Memorandum Planning and Urban Development Department Planning Division

To: Chair Boepple and Members of the Portland Planning Board
From: Jean Fraser, Planner
Date: February 5th, 2016
Re: **February 9th Planning Board Workshop**
Level III Subdivision and Site Plan:
Redevelopment to create 4 residential units, 31 Fore Street
Bob and Carrie LeBlanc, Peninsula Property Development, Applicants

DRIVEWAY APRON LAYOUT DETAIL
NOT TO SCALE

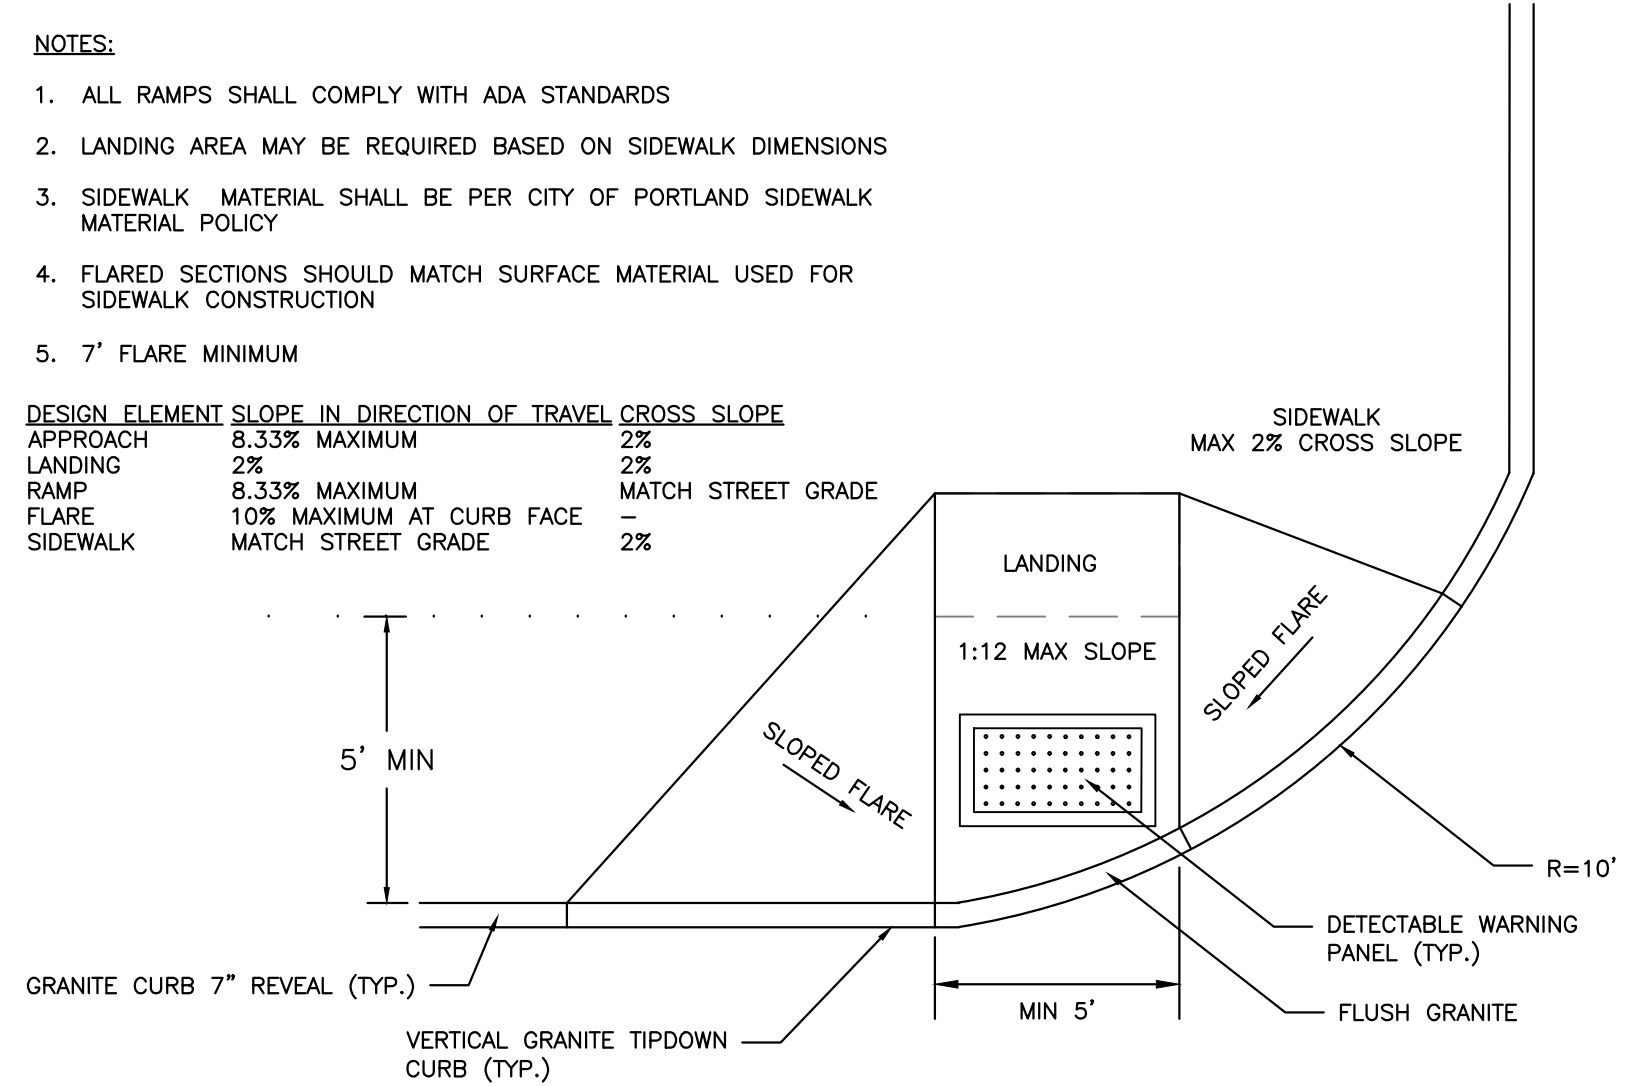
The proposals include a relocated driveway which improves the separation from the adjacent Waterville Street property driveway but brings it to 31 feet from the corner of Fore/Waterville, which does not meet the 35 foot Technical Standard for corner clearance. The applicant has indicated that they will need to request a waiver due to architectural constraints (Attachment O) although a detailed waiver request has not been submitted.

This particular waiver is not often granted. In looking at the plans, it appears there may be scope to increase the distance from the corner even if not to the full 35 feet. The Department of Public Works David Margolis-Pineo has requested the applicant look again at ways to meet the standard (Attachment 5) and the Traffic Engineer Reviewer Tom Errico is supportive of a waiver in principle due to the particular characteristics of this location (Attachment 6).

TREE PLANTING DETAIL
NOT TO SCALE

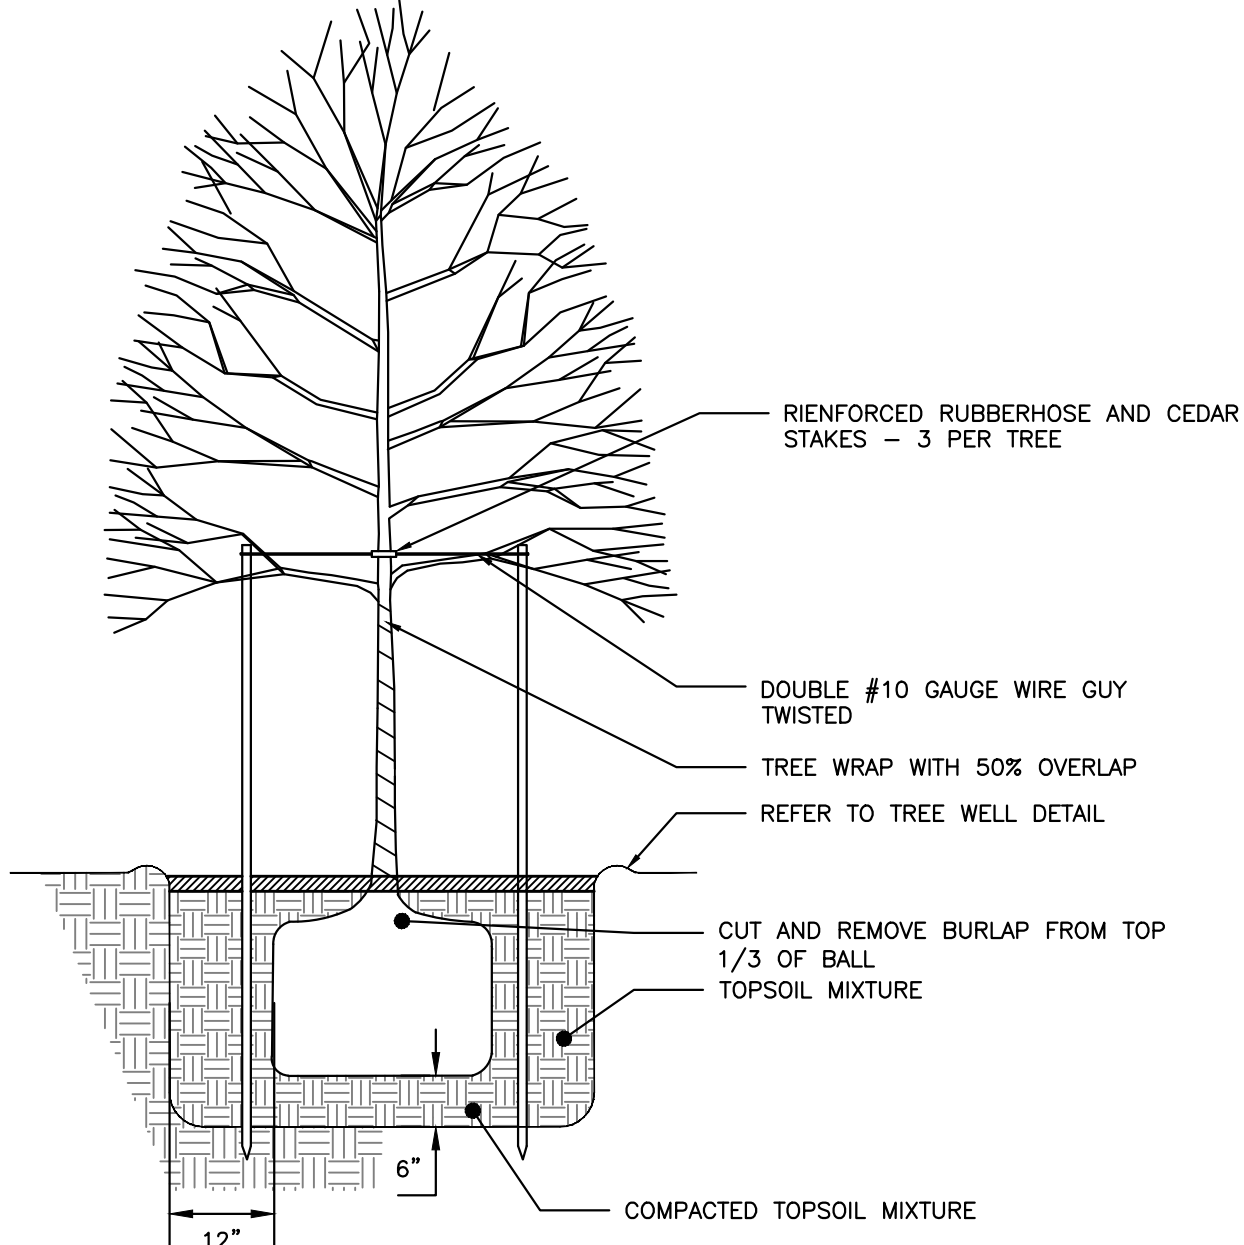
Street trees - The two new street trees proposed for Waterville Street should be 'Autumn Gold' Ginkgo 2" caliper, planted in 4 x 7' tree cut outs in the walk. Exact tree locations should match the 'in-between' spaces for any on-street parking to help avoid door openings into the tree trunk.

TREE PROTECTION DETAIL
NOT TO SCALE

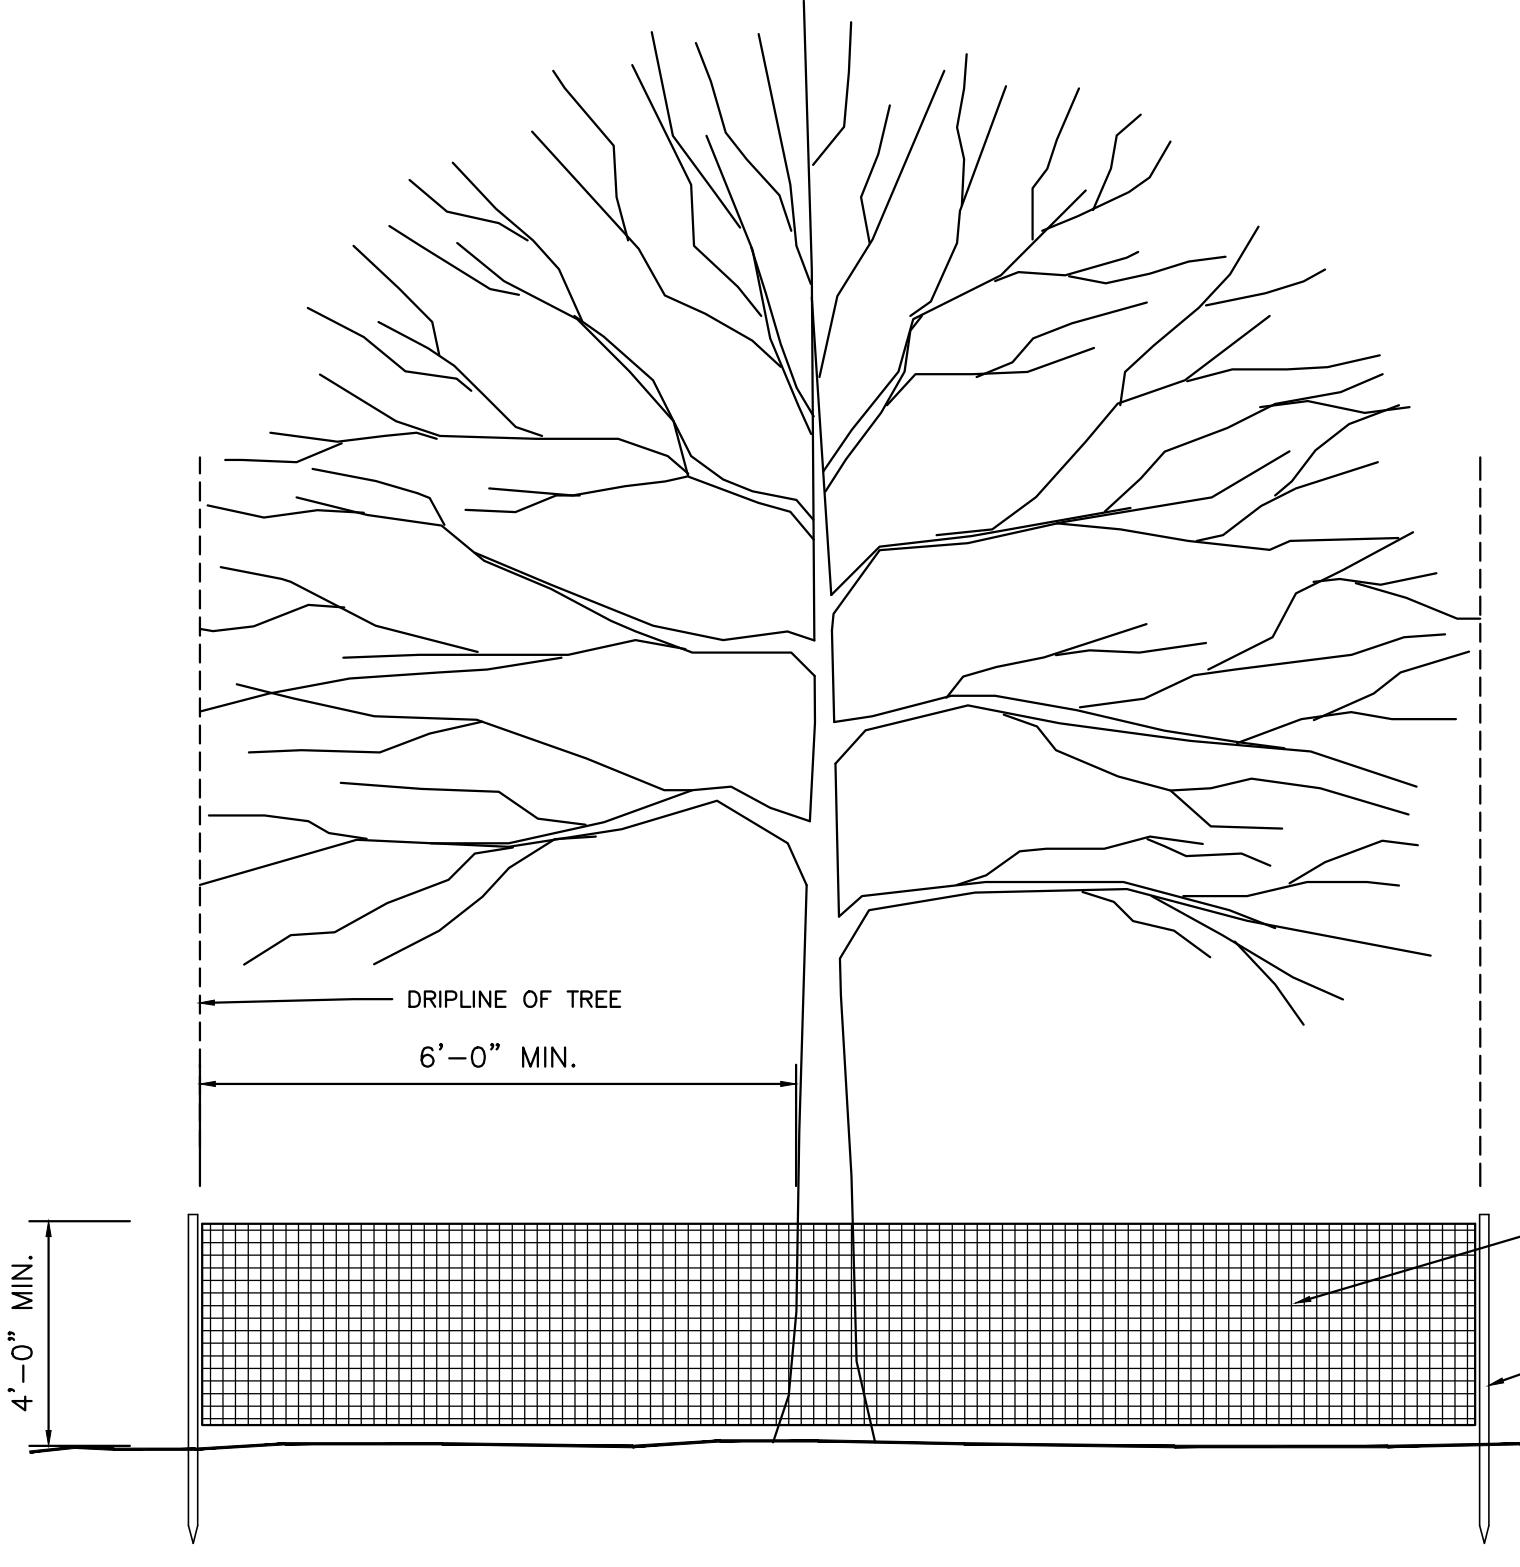
The street tree along Fore Street should be protected during construction, any broken branches damaged should be pruned as part of the project.

SOIL FILTER CROSS SECTION

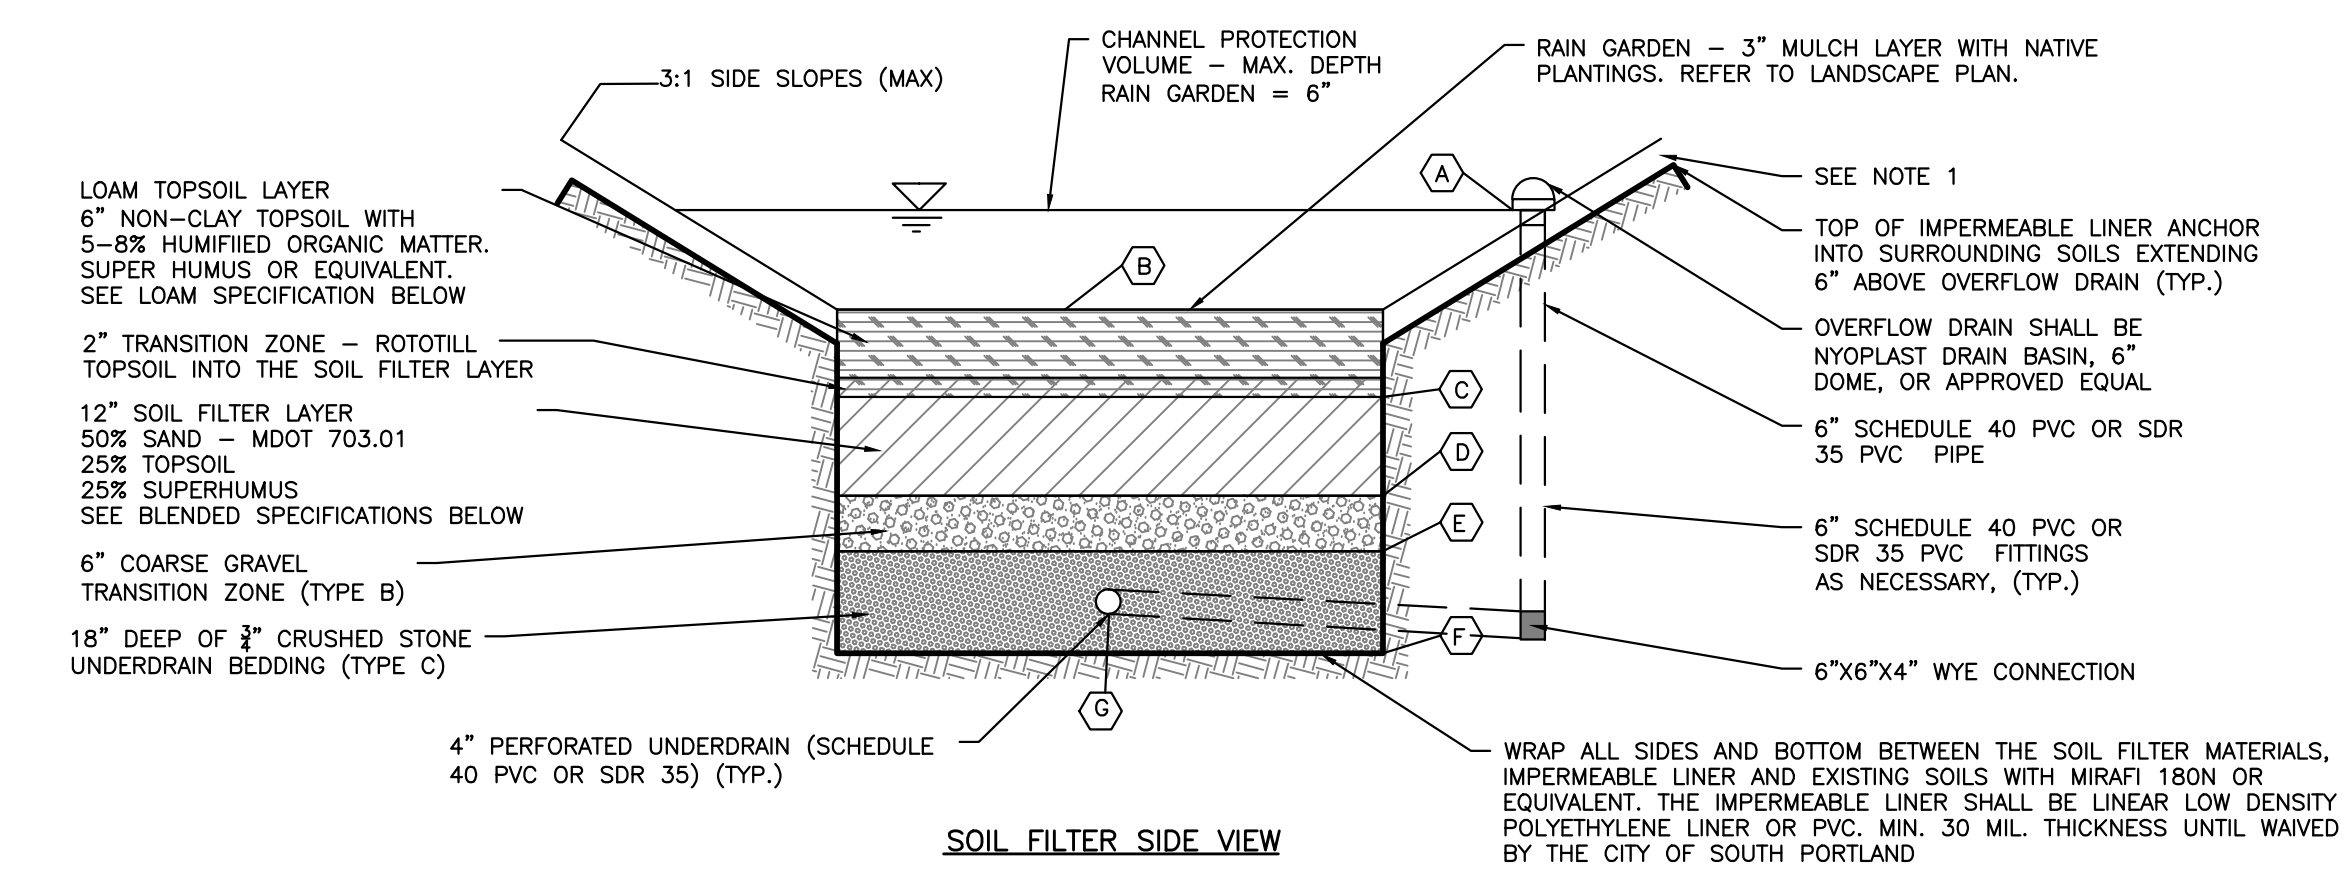
Rain Garden - Specific details on the rain garden are requested, if the project is to qualify for 'Stormwater' credits the project should follow Portland Water Resources 'rain garden' guidelines.
